APPROVED
Limited building only review
Permit holder responsible for full compliance with the code

289 BRET ROAD RESIDENCE
CAMERON, HARNETT COUNTY, NORTH CAROLINA

SHEET TITLE:
ELEVATIONS / BUILDING DATA

1 FLOOR PLAN
1/4" = 1'-0"

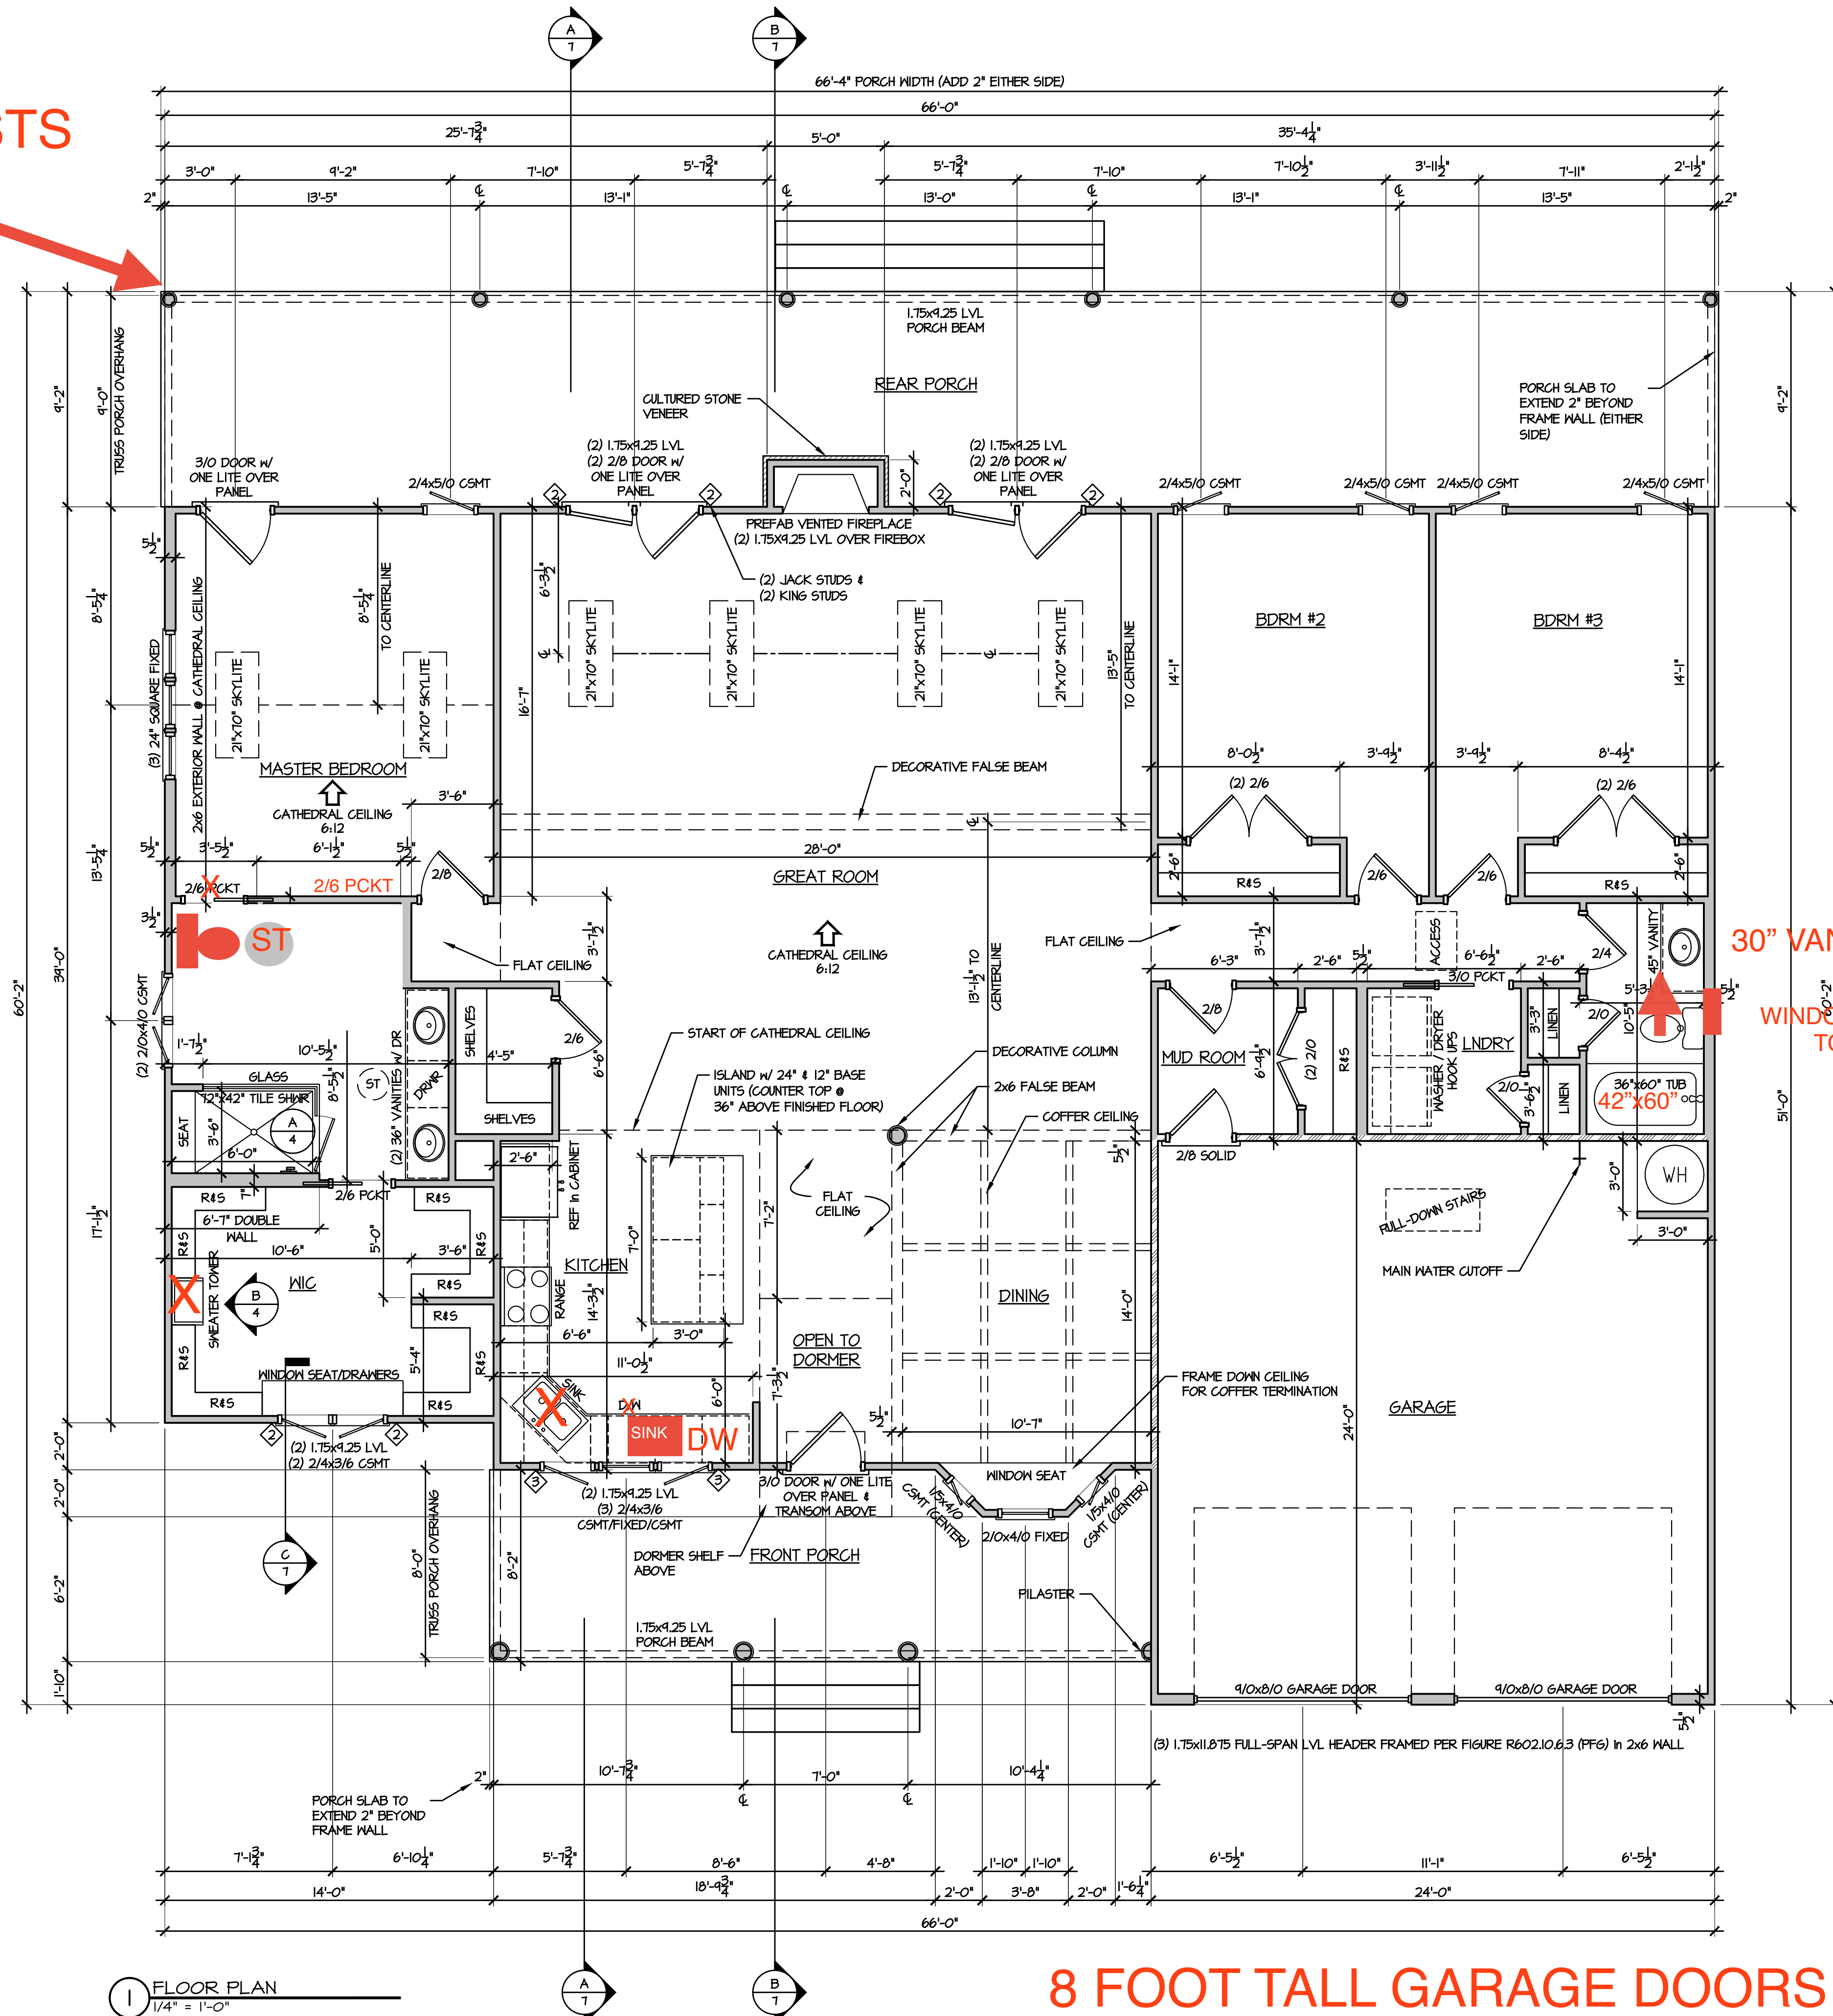
Caseмент windows shall have side hinge egress kits to meet minimum clear egress width of 20"

6

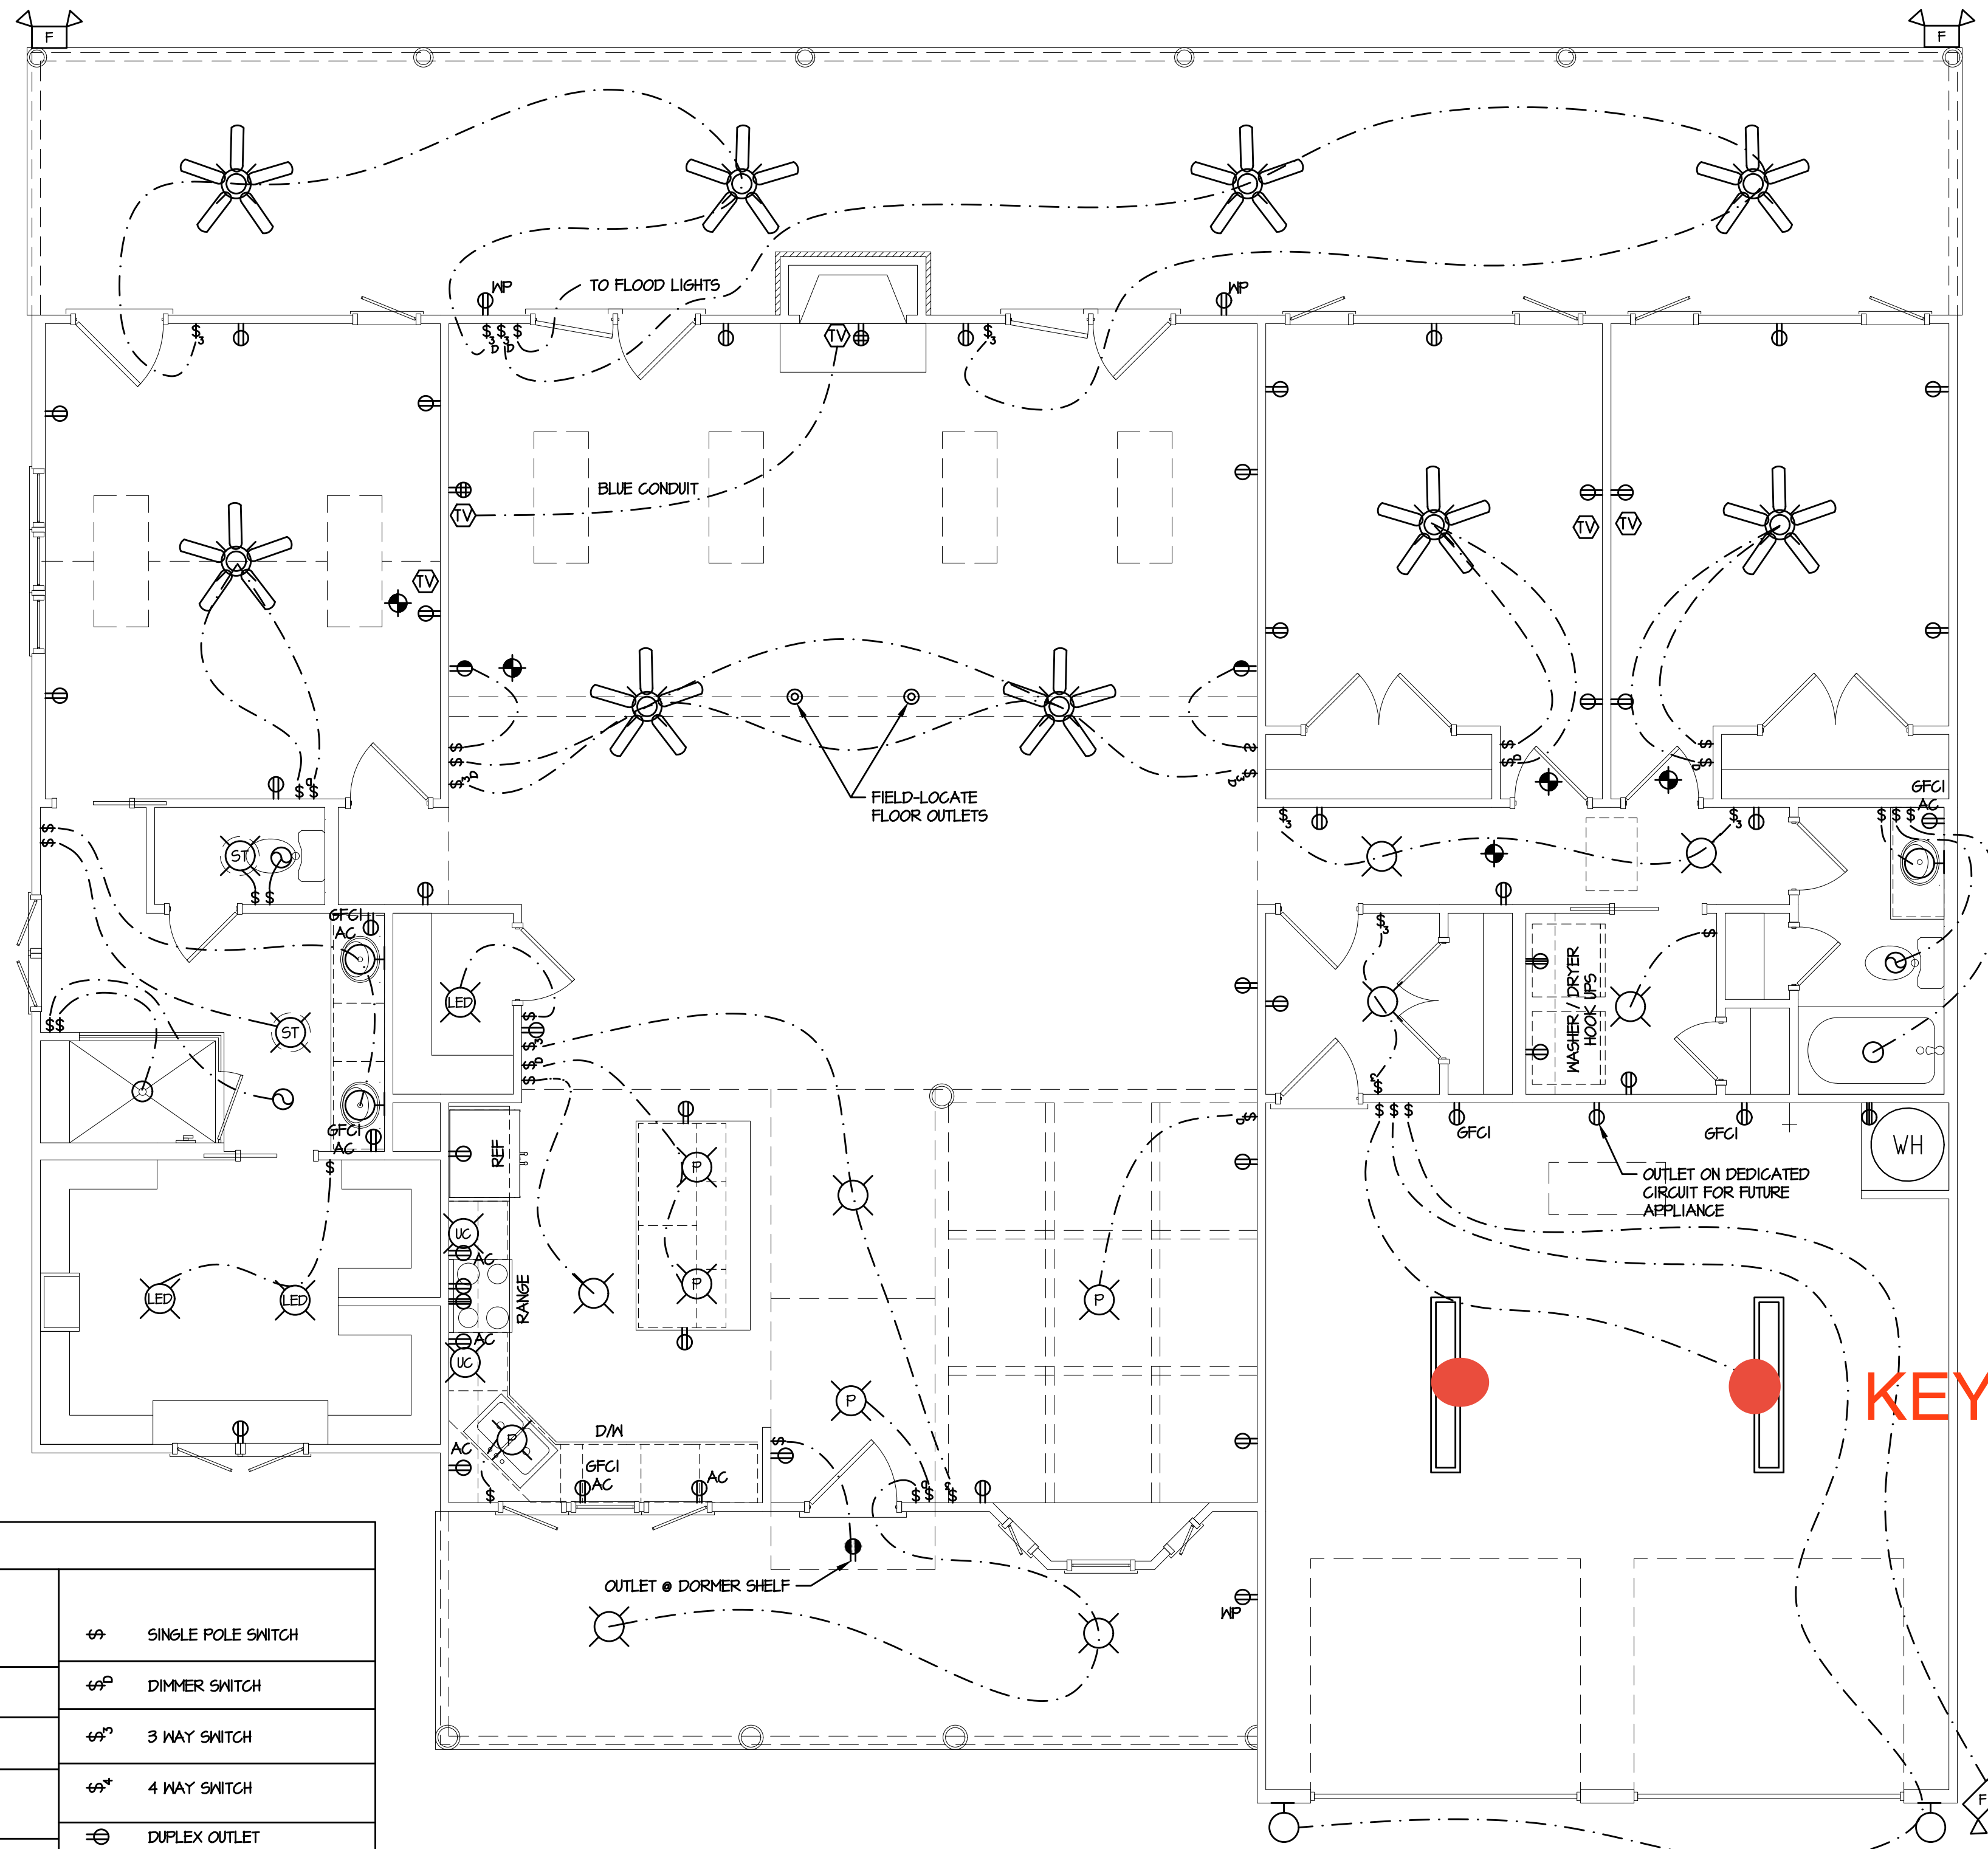
Ceiling receptacles for 8 foot tall garage doors

(C) TYPICAL WALL SECTION
3/4" = 1'-0"

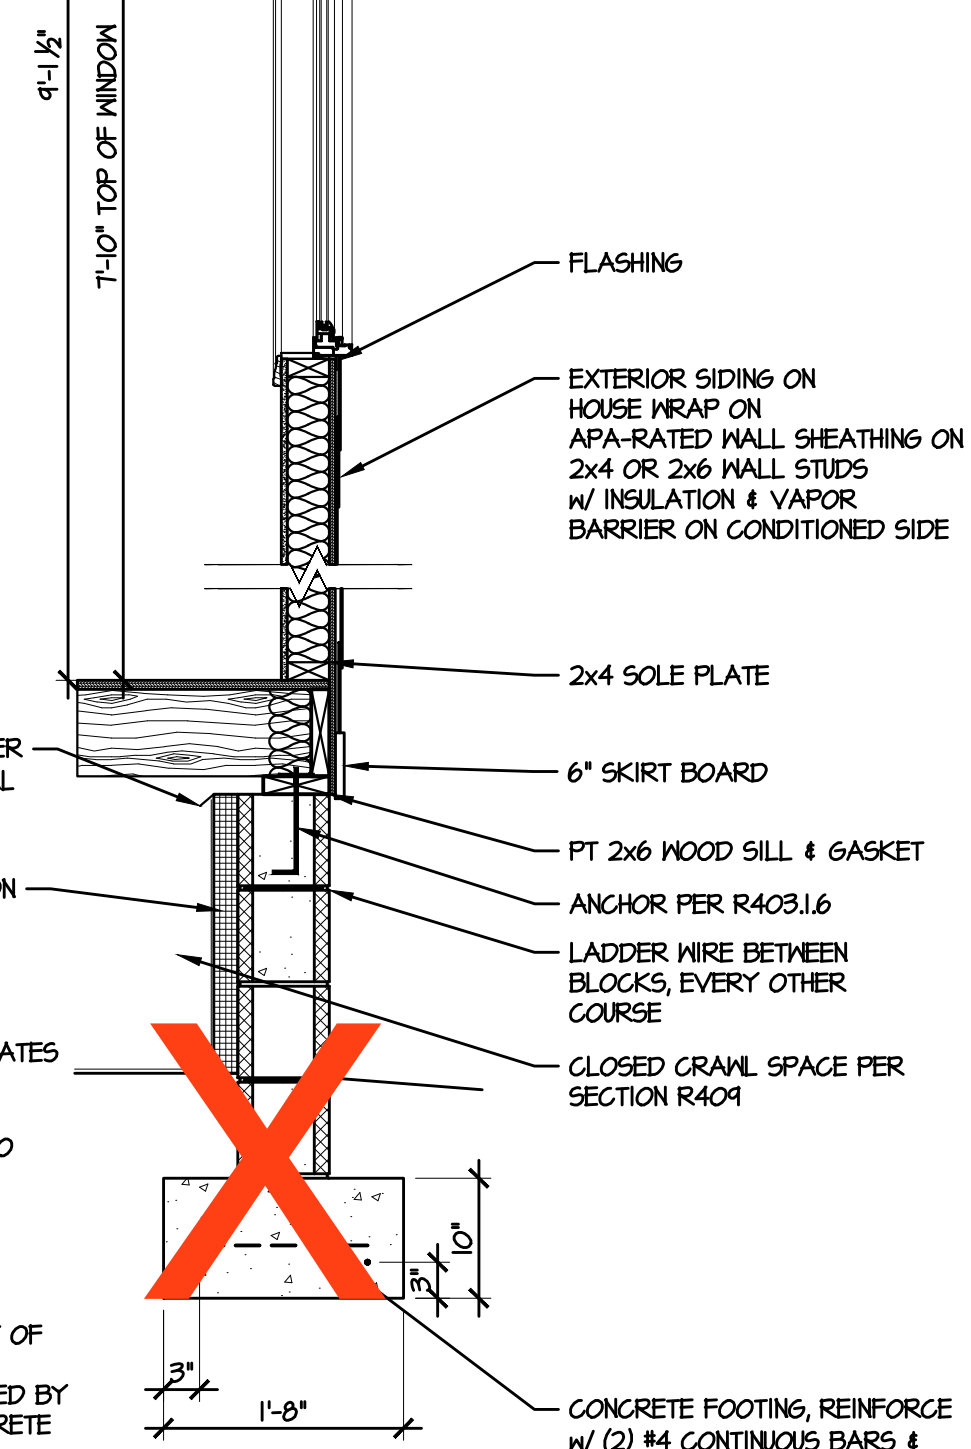
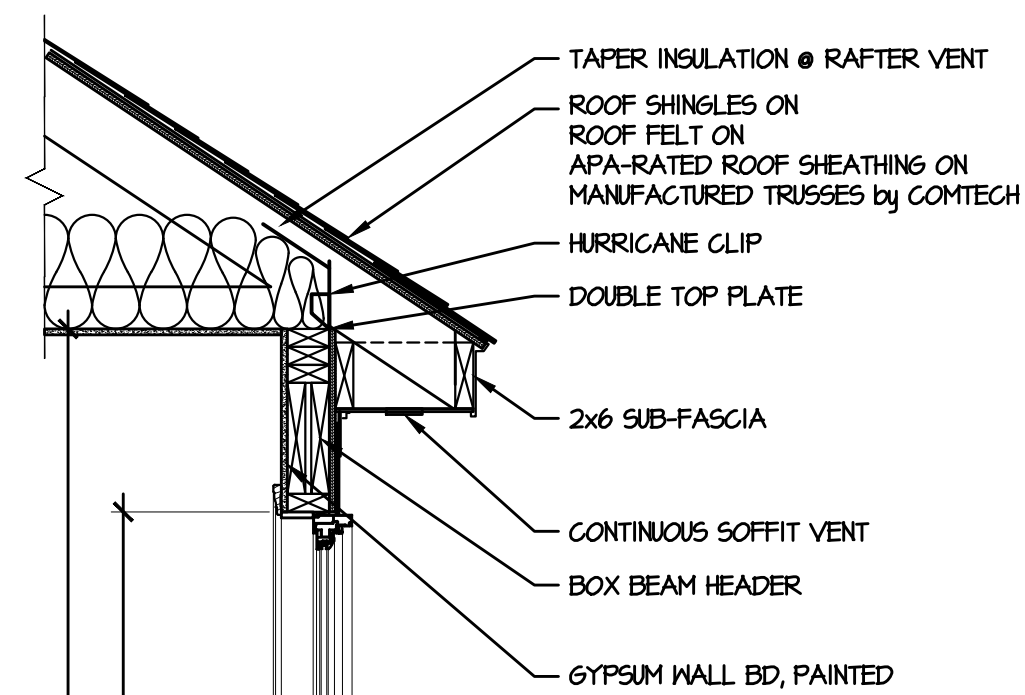
4 and 8 brick and block foundation wall. See attachment.

R403.1.6 FOUNDATION ANCHORAGE.
 WOOD SILL PLATES AND WOOD WALLS SUPPORTED DIRECTLY ON CONTINUOUS FOUNDATIONS SHALL BE ANCHORED TO THE FOUNDATION IN ACCORDANCE WITH THIS SECTION.
 WOOD SOLE PLATES AT ALL EXTERIOR WALLS ON MONOLITHIC SLABS, WOOD SOLE PLATES OF BRACED WALL PANELS AT BUILDING INTERIORS ON MONOLITHIC SLABS AND ALL WOOD SILL PLATES SHALL BE ANCHORED TO THE FOUNDATION WITH MINIMUM 1/2-INCH-DIAMETER (12.7 MM) ANCHOR BOLTS SPACED NOT GREATER THAN 6 FEET (1829 MM) ON CENTER OR APPROVED ANCHORS OR ANCHOR STRAPS SPACED AS REQUIRED TO PROVIDE EQUIVALENT ANCHORAGE TO 1/2-INCH-DIAMETER (12.7 MM) ANCHOR BOLTS. BOLTS SHALL EXTEND NOT LESS THAN 7 INCHES (178 MM) INTO CONCRETE OR GROUTED CELLS OF MASONRY UNITS. THE BOLTS SHALL BE LOCATED IN THE MIDDLE THIRD OF THE WIDTH OF THE PLATE. A NUT AND WASHER SHALL BE TIGHTENED ON EACH ANCHOR BOLT. THERE SHALL BE NOT FEWER THAN TWO BOLTS PER PLATE SECTION WITH ONE BOLT LOCATED NOT MORE THAN 12 INCHES (305 MM) FROM THE CORNER.

INTERIOR BEARING WALL SOLE PLATES ON MONOLITHIC SLAB FOUNDATION THAT ARE NOT PART OF A BRACED WALL PANEL SHALL BE POSITIVELY ANCHORED WITH APPROVED FASTENERS. SILL PLATES & SOLE PLATES SHALL BE PROTECTED AGAINST DECAY AND TERMITES WHERE REQUIRED BY SECTIONS R317 AND R318. ANCHOR BOLTS SHALL BE PERMITTED TO BE LOCATED WHILE CONCRETE IS STILL PLASTIC AND BEFORE IT HAS SET. WHERE ANCHOR BOLTS RESIST PLACEMENT OR THE CONSOLIDATION OF CONCRETE AROUND ANCHOR BOLTS IS IMPEDED, THE CONCRETE SHALL BE VIBRATED TO ENSURE FULL CONTACT BETWEEN THE ANCHOR BOLTS AND CONCRETE.
